Y/15/25/PL

Stakers Farm North End Road Yapton BN18 0DU

Conversion of and alterations to existing barns to create 3 No dwellings, erection of car barn, demolition of existing buildings and associated landscaping and parking and erection of new garage/workshop for Stakers Farmhouse and upgrading of access track. This application affects the character and appearance of the Main Road/Church Road, Yapton Conservation Area

BARN 1 PROPOSED SOUTH WEST COURTYARD ELEVATION SHOWING SHUTTERS OPEN

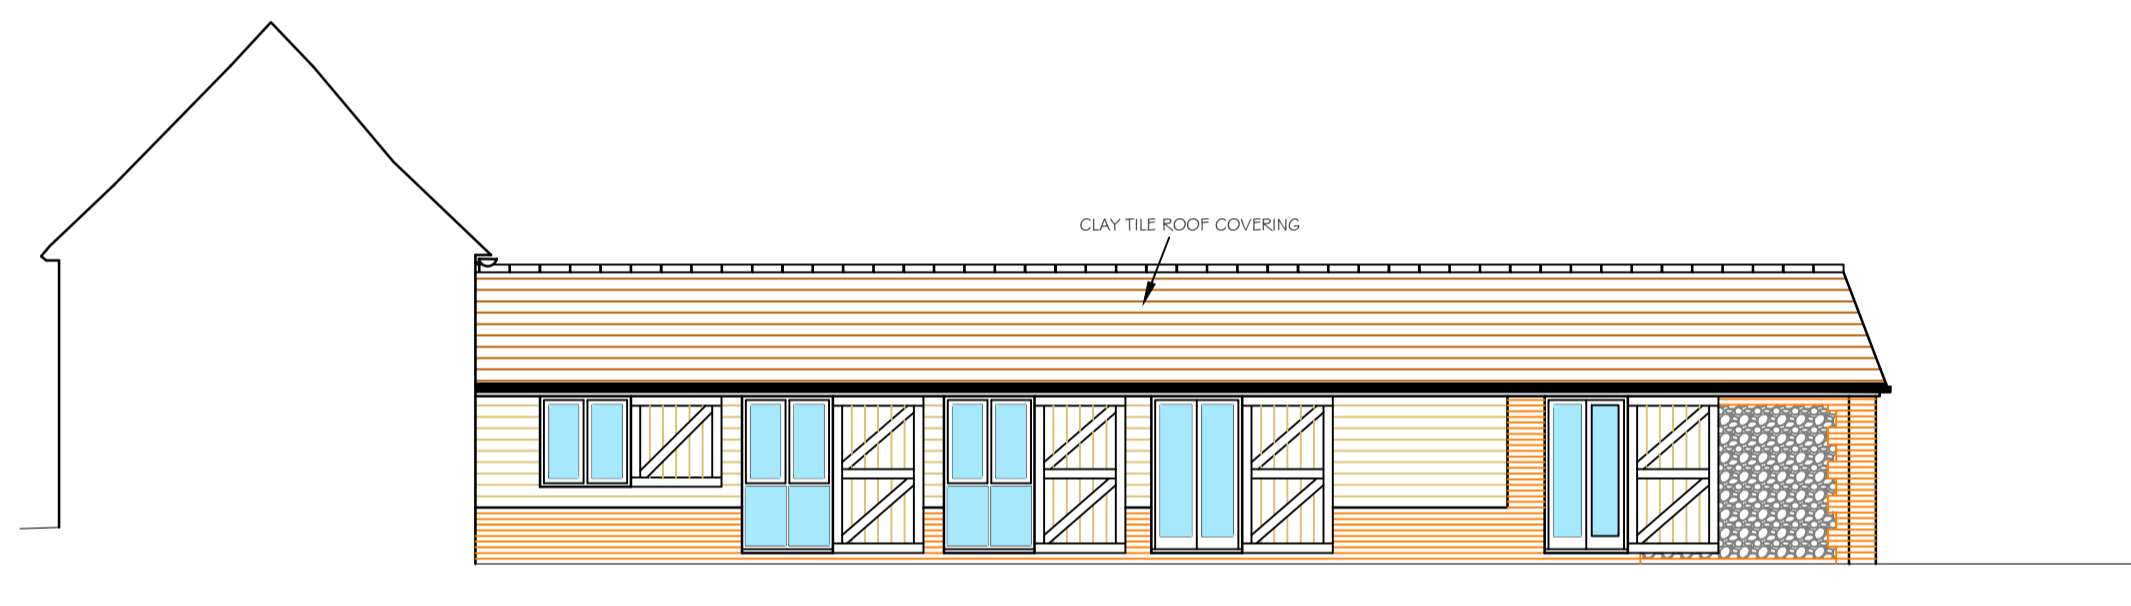
It is not clear why a variety of windows were chosen for the S.W courtyard elevation of barn one, when a more uniform appearance would be appropriate here. This requires clarification from the applicant, and it is suggested that more appropriate designs are prepared here.

SECTION THROUGH BARN 1 IN AREA OF EXISTING FLINT / BRICK FLOOR  
 SCALE - 1:50

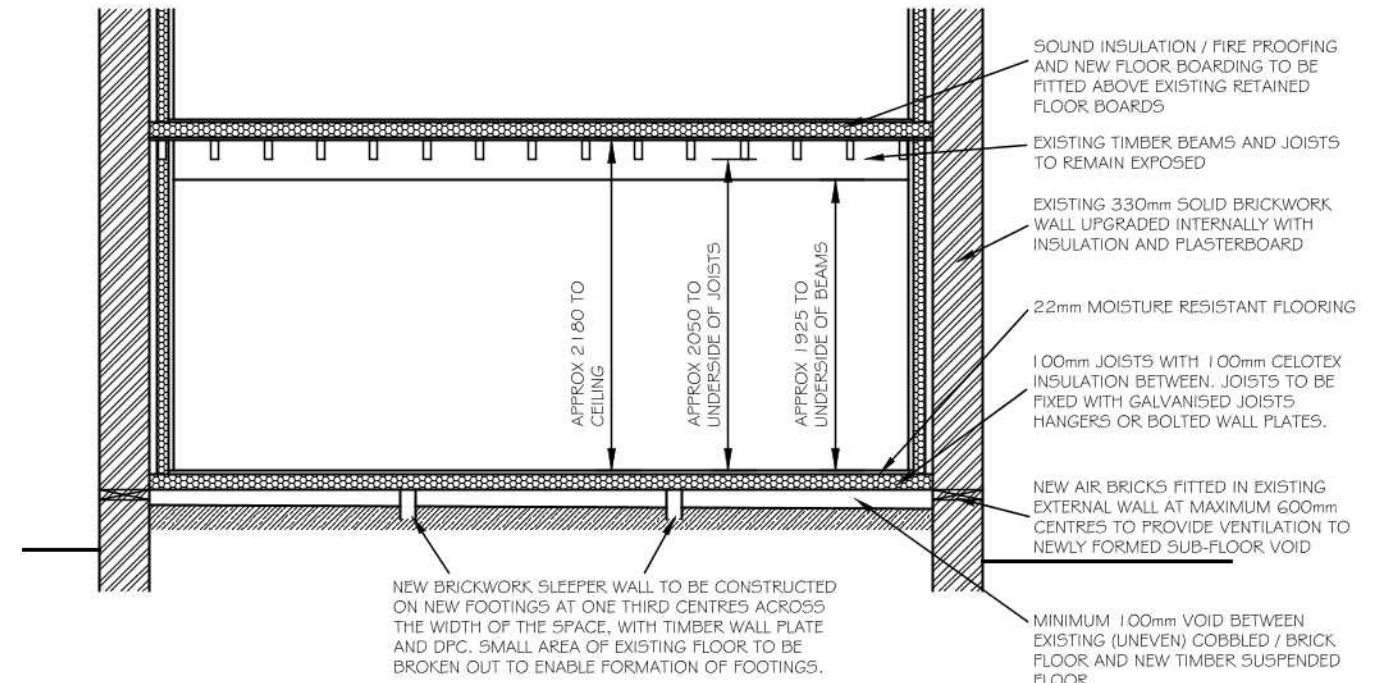
Having previously undertaken a site visit it is clear that some parts of the barn to be converted into unit one retains some attractive features, especially within the two-storey element. These features are some of the most attractive within the barns and include flint flooring, exposed brick walls, a timber ceiling and stall dividers. It is positive to understand that the flooring will remain in place and be sensitively covered so as to not cause harm to the historic fabric. Likewise, the retention of the exposed beams and joists in the ceiling will enable some of the character of the space to be preserved and help shape the character of the development. It would be helpful to understand how

they will be treated i.e. left untreated or treated (and how). This information could be provided for by way of condition.

DRAWING TITLE
 PROPOSED TYPICAL JOINERY DETAILS
 OF NEW WINDOWS AND EXTERNAL
 DOORS

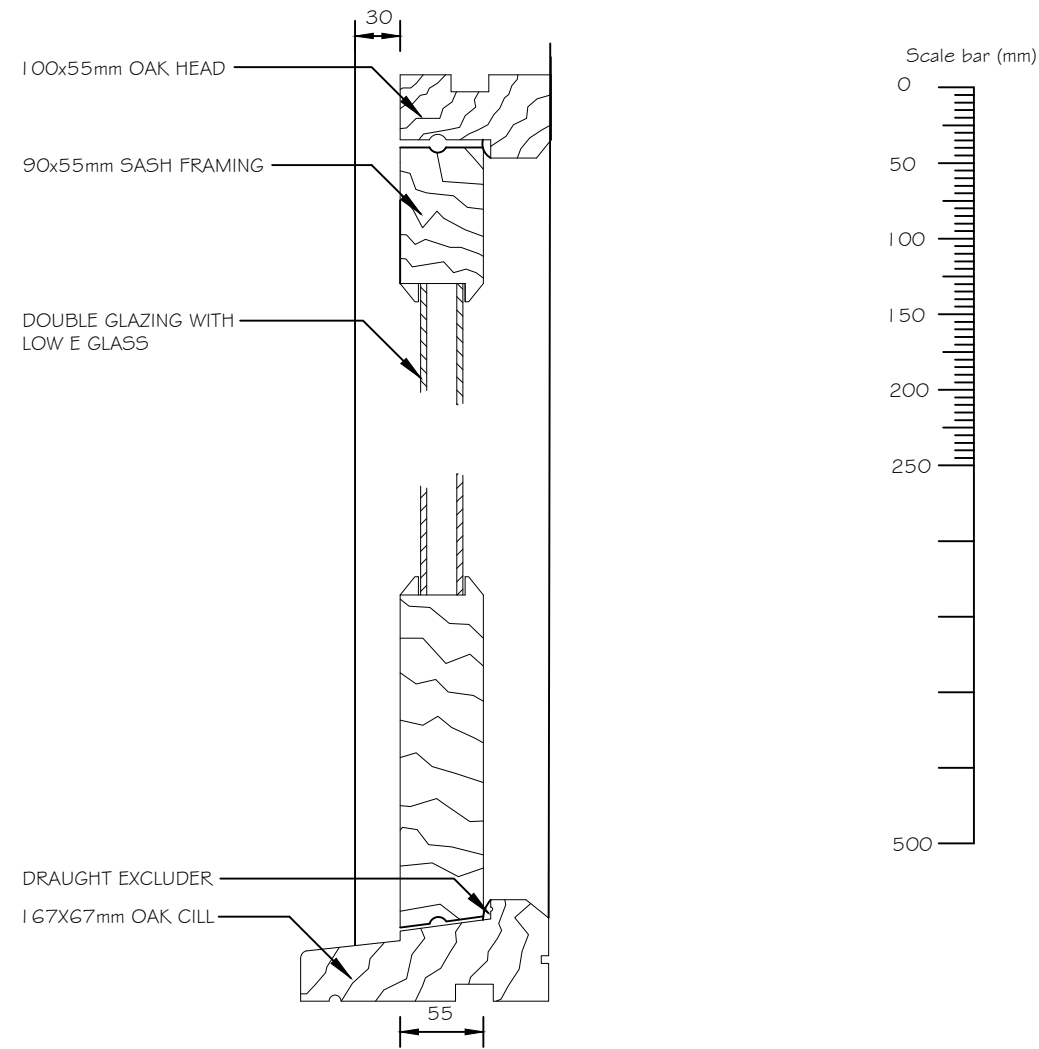
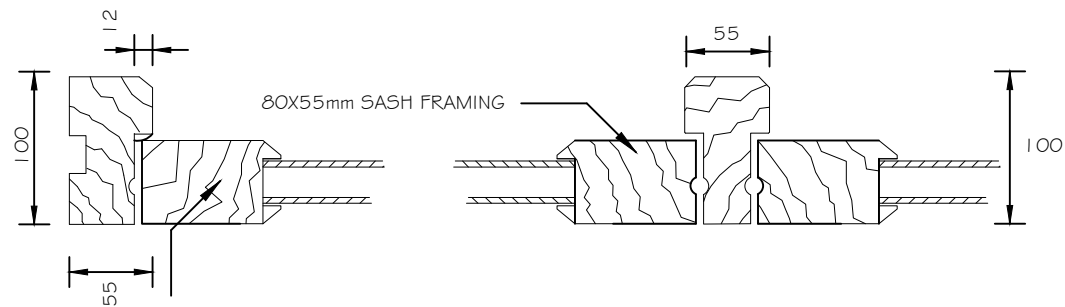
A Historic England Guidance note regarding adapting traditional farm buildings states that 'New doors and windows will inevitably be required for habitable accommodation but that standard 'off the peg' joinery will never look substantial enough for buildings characterised by large robust frame sections. It is noted that the proposals will generally utilise existing openings for windows and doors. Such an approach is positive. Whilst some sectional details have been provided for the windows and doors, which is of assistance, other information is provided in the elevation drawings. At present, I am concerned that in elevation (as opposed to materials) that they are of a more standard design which appear too "domestic" in style, and out of character with the original purpose of the building i.e. a simple agricultural building. It would also appear that the design of the windows is such that it is possible to understand which of the casements open, and which do not (i.e. more like a 'storm window design' as opposed to a more traditional one). It is suggested that further thought could be given to this element of the design and a more appropriate windows and door design provided.

The glazing of openings is a particularly subtle aspect of design in farm building adaptation work. In masonry structures setting glazing deep in the reveal of existing openings (which were rarely glazed) creates shadow lines and minimises reflections and impact. It would appear that the glazing and frames are to be recessed in order to reduce reflections and visual impact and be constructed from timber. This is a positive element of the windows/doors.

BLOCK PLAN  
1:500

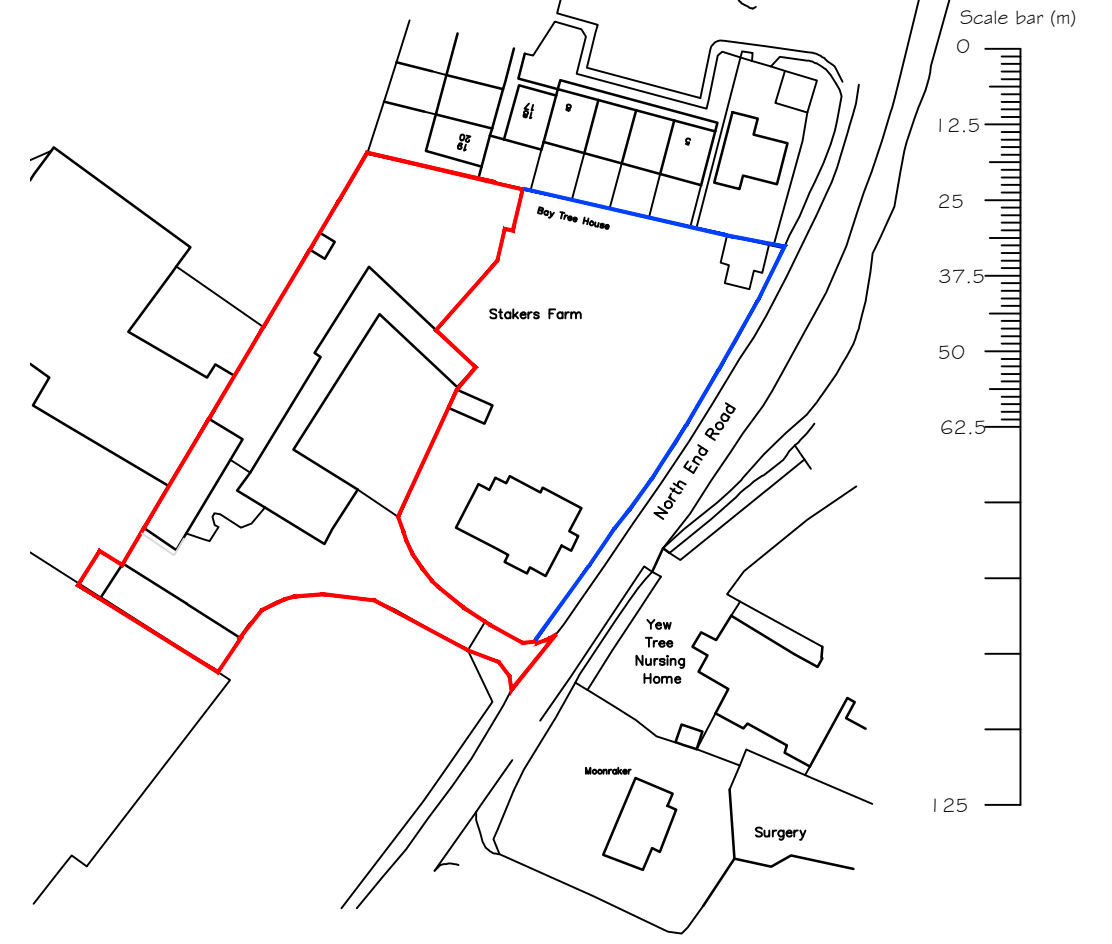
The use of brick pavements is of some concern, as this could introduce a sub-urban character into what should be a more rural one. From looking at the site plan it would appear that a significant area of the site would be paved in order to provide access to the parking courtyard. It is not clear why such a material was chosen, when something more in keeping would be more appropriate. However, if carefully chosen, it could be that such an approach would be acceptable. A sample of the material would be requested so as to fully assess the impact.
